From: Amanda Scholes on behalf of Planning.Responses
Sent: 30 March 2021 10:08
To: Planning Scanning
Subject: FW: Planning Consultation on: LY/4/21/DOC

From: Paul Cann <Paul.Cann@arun.gov.uk>
Sent: 29 March 2021 15:46
To: Planning.Responses <Planning.Responses@arun.gov.uk>
Cc: Finlay Gardner <Finlay.Gardner@arun.gov.uk>
Subject: RE: Planning Consultation on: LY/4/21/DOC

(Relating to condition no.3 of LY/10/17/PL)

Application No: LY/4/21/DOC
Registered: 10th March 2021
Site Address: Comfort Inn Lyminster Road Lyminster BN17 7QQ
Description of Works: Approval of conditions imposed under LY/10/17/PL relating to condition 3-surface water drainage.

TANK SEWER c/w CONTROL CHAMBER & INLET CATCHPIT

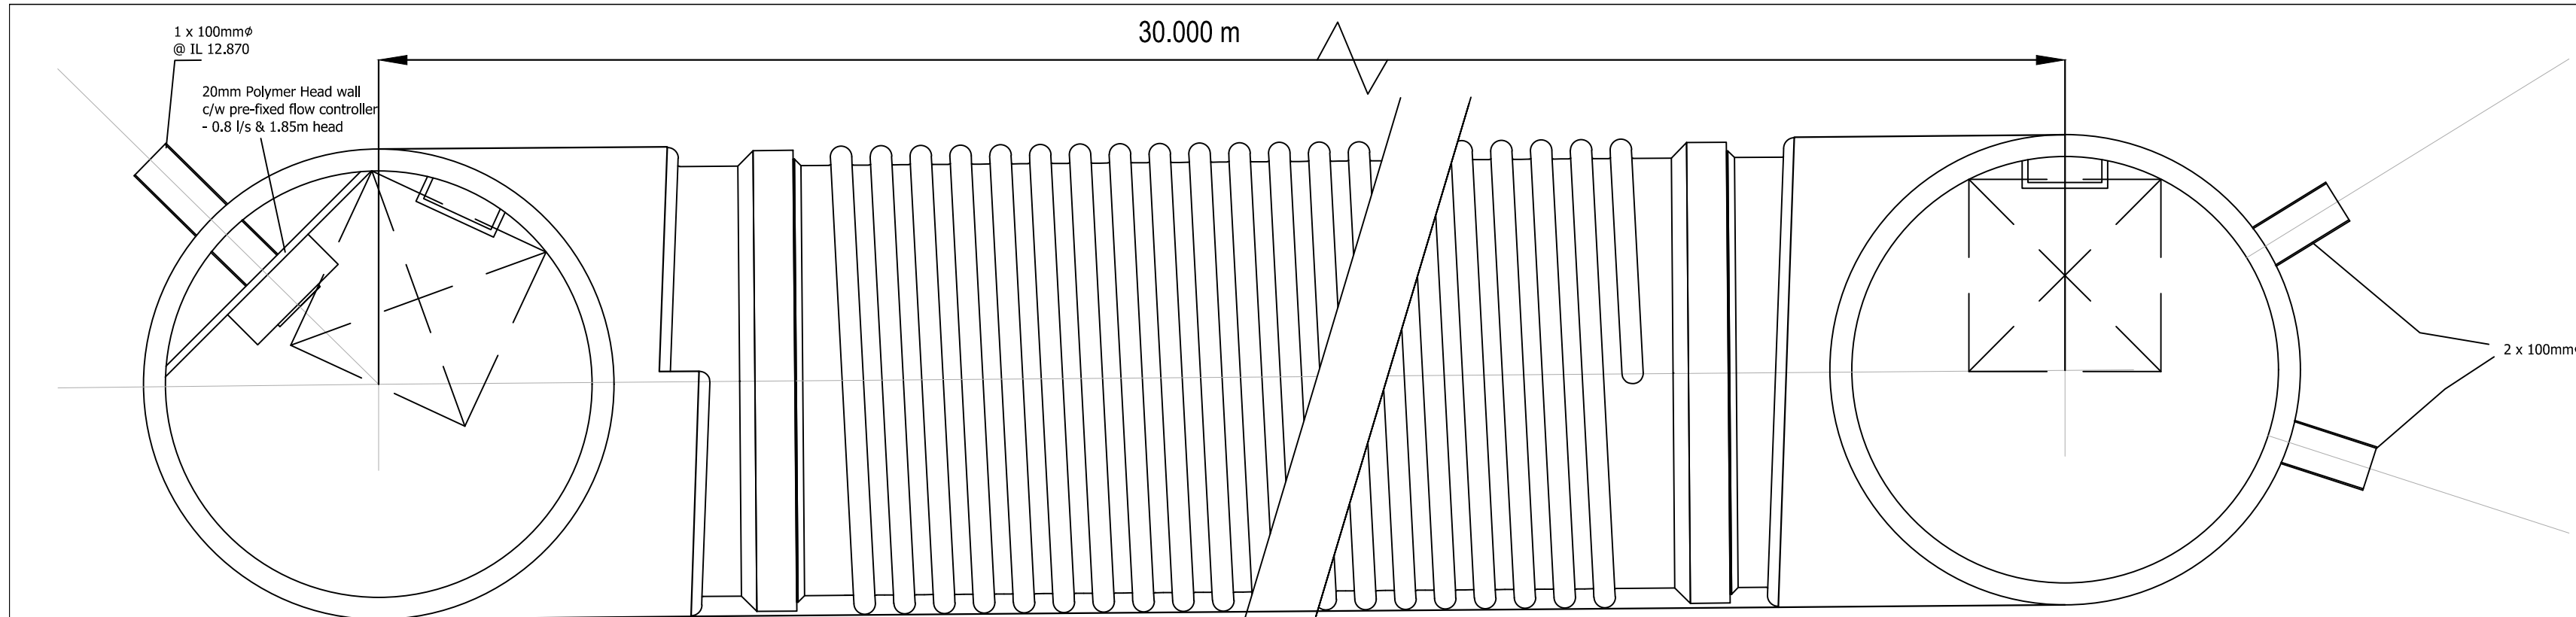
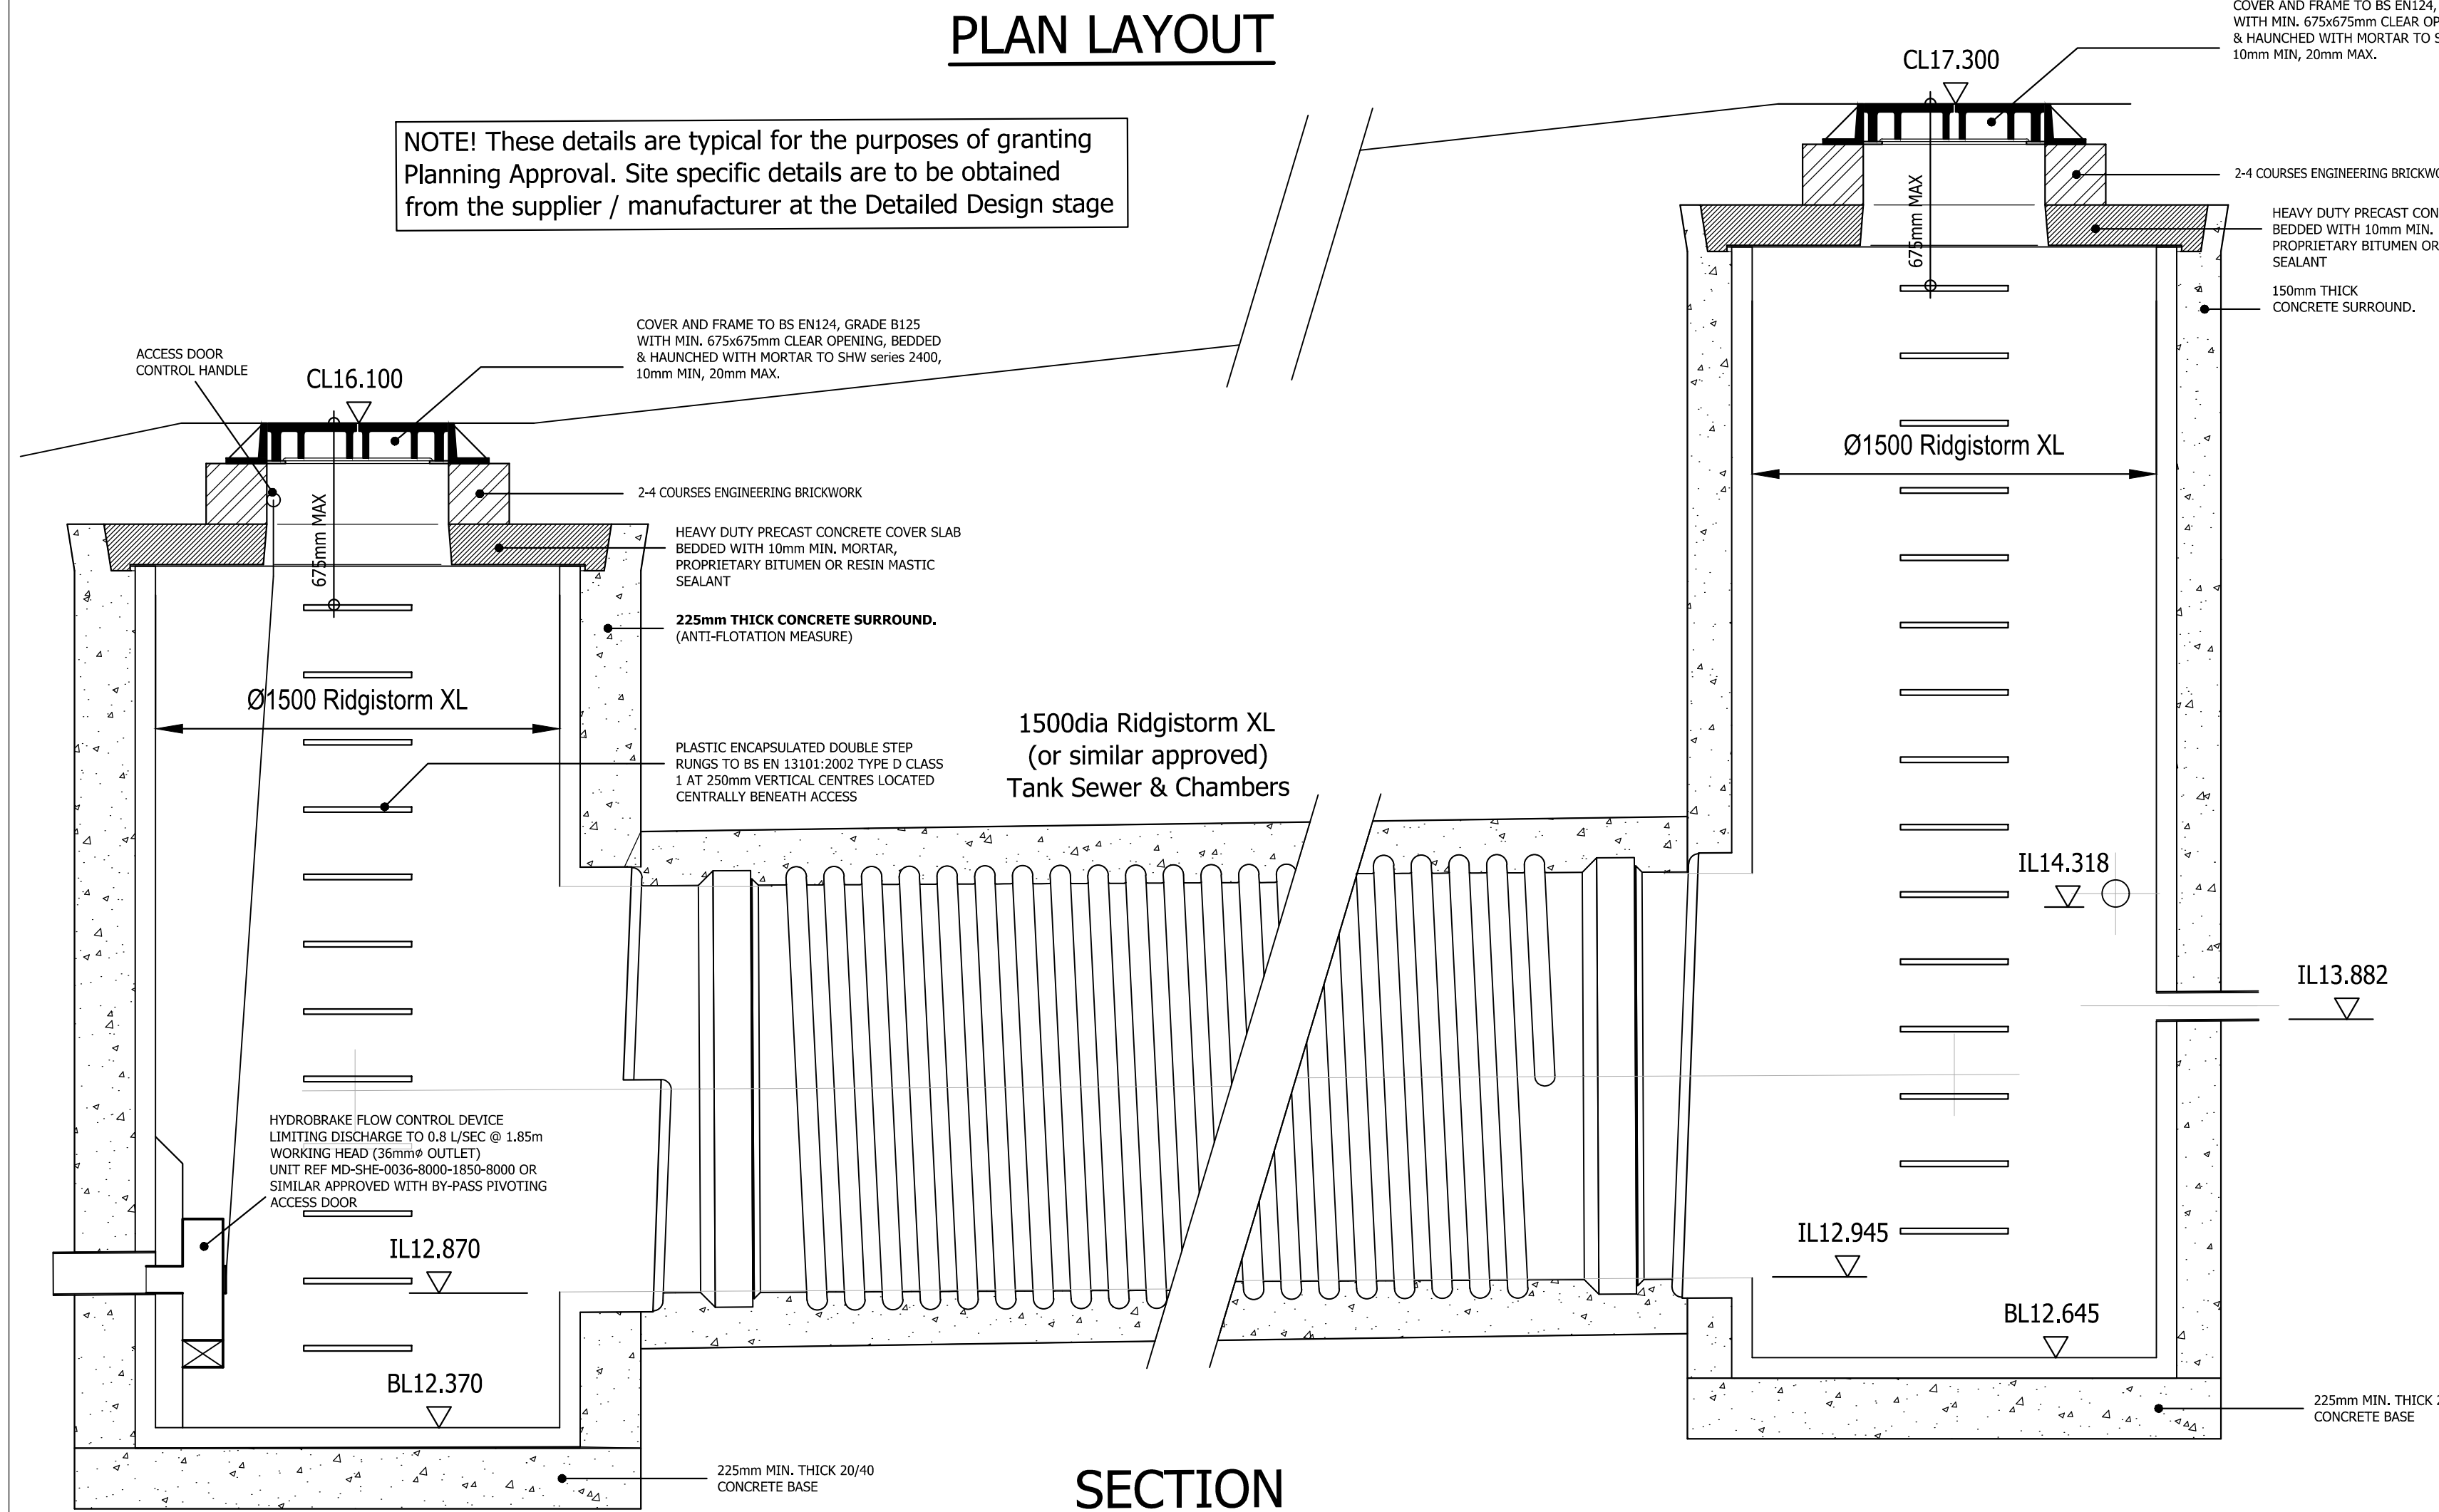
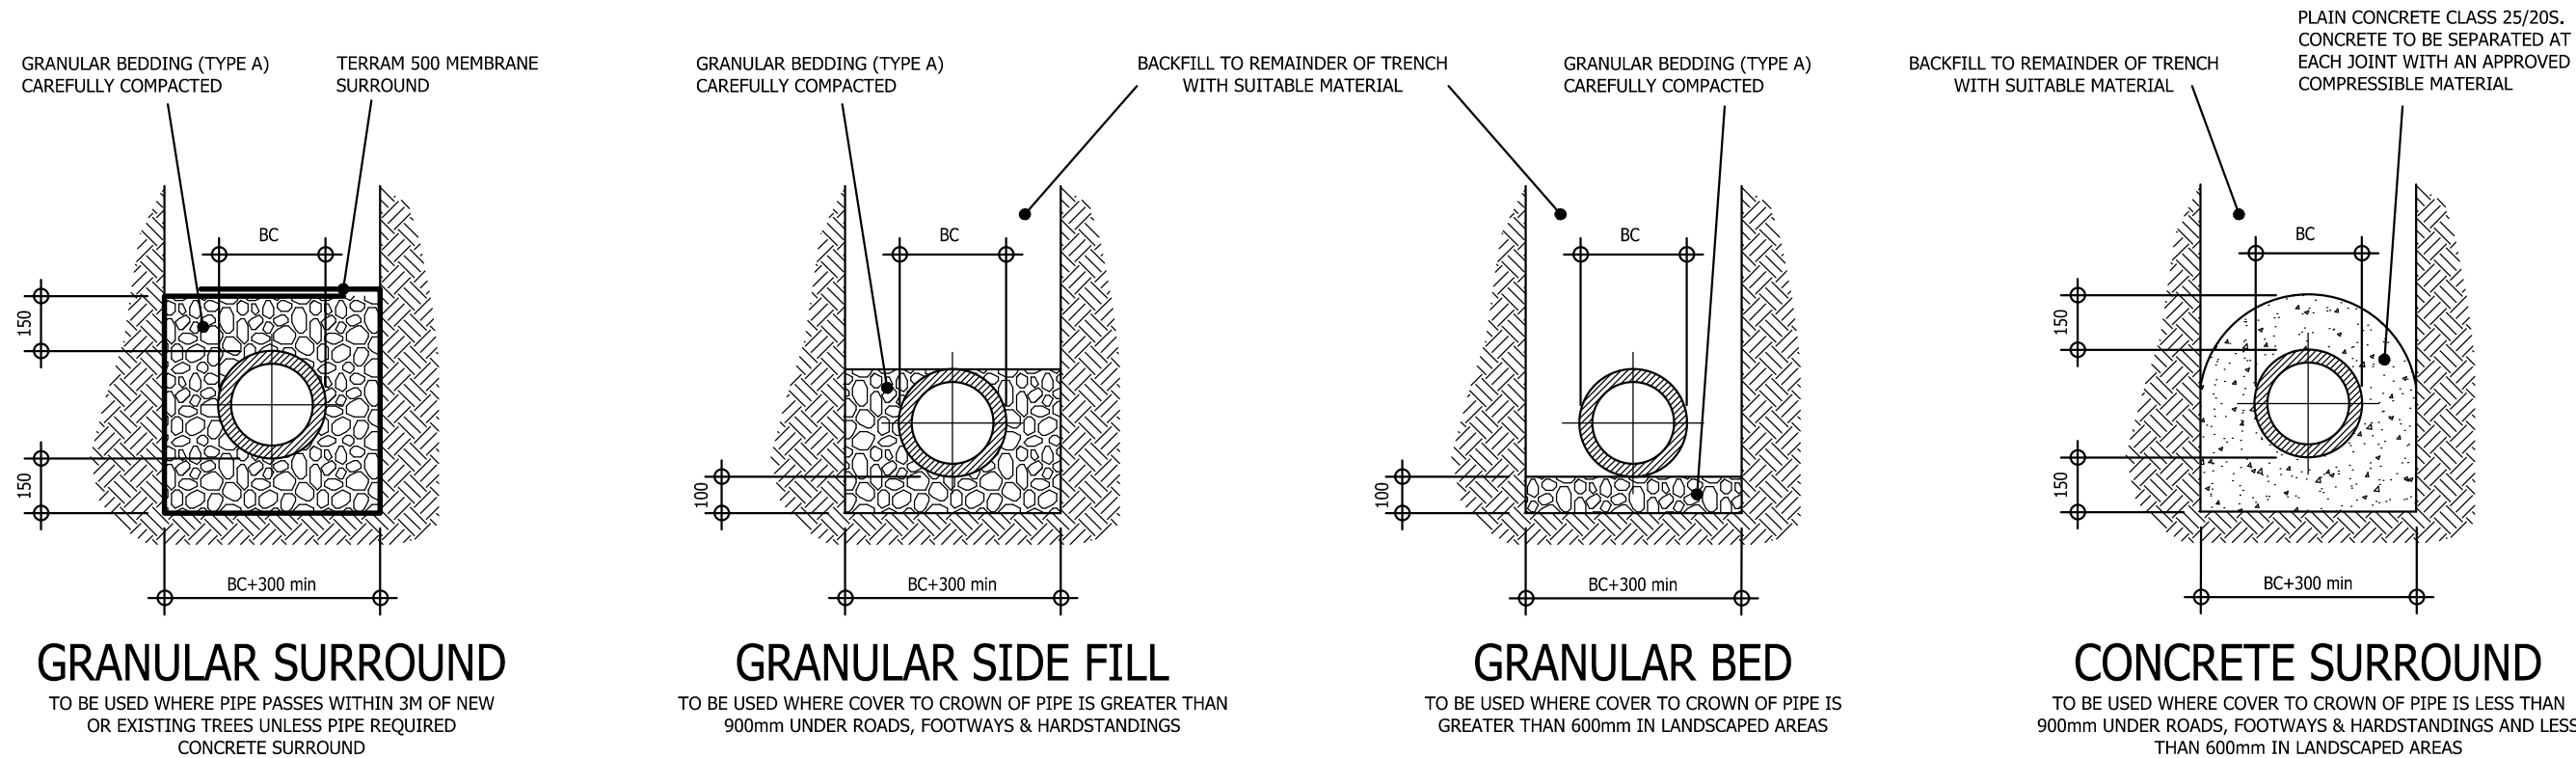
1. The construction details for the storage tank need to reflect the revised levels/outlet orientation, etc.
